**Consultation Response from KC,
Lead Local Flood Authority**

2023/91405 Part of former St Luke's Hospital site, Blackmoorfoot Road, Crosland Moor, Huddersfield, HD4 5RA

Erection of foodstore (class E) with associated access, parking, servicing area and landscaping

Date Responded: 09/04/2024.

Drawing title			
Drainage Strategy			
Drawn JS	Chkd RT	Date AUG 2022	Scale As Shown @ A1
Contract No. 21561		Drg No. DR-C-0100	Revision P5

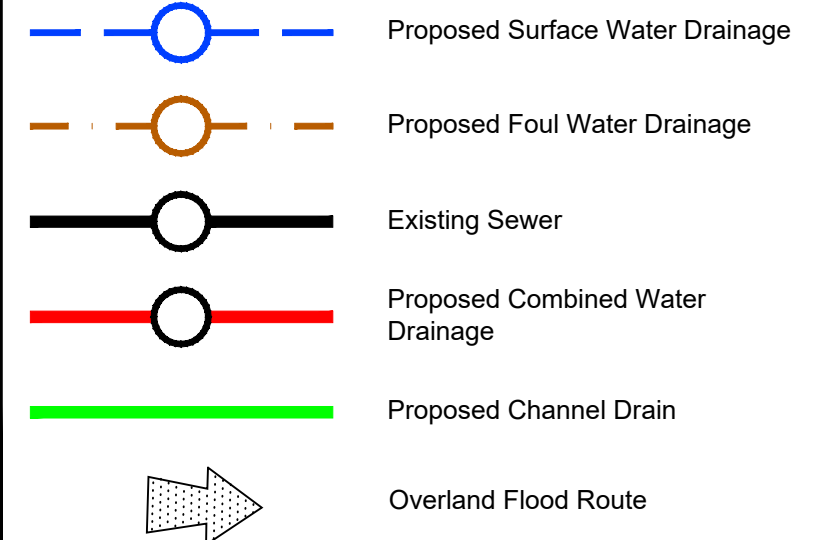
- The upstream MH should be a PCC chamber 1.2m diameter as shown on the Drainage Strategy drawing and should be a silt trap type.
- The tank and impermeable geo-membrane should be replaced after 25 years unless the developer has BBA (or similar) certification proving that the design life of these elements is longer – in which case the tank and membranes will need to be replaced at the end of their guaranteed design life.

The MD Hydraulic Calculations indicate a maximum water level of 147.288 during the critical 1 in 100 year (plus CC) rainfall event, however it is noted on the Drainage Drawing that levels are to be capped at **146.650** to prevent overtopping of the channel drain. The LLFA therefore **cannot accept** these calculations as surface water run-off will not be contained within the site during the critical rainfall event.
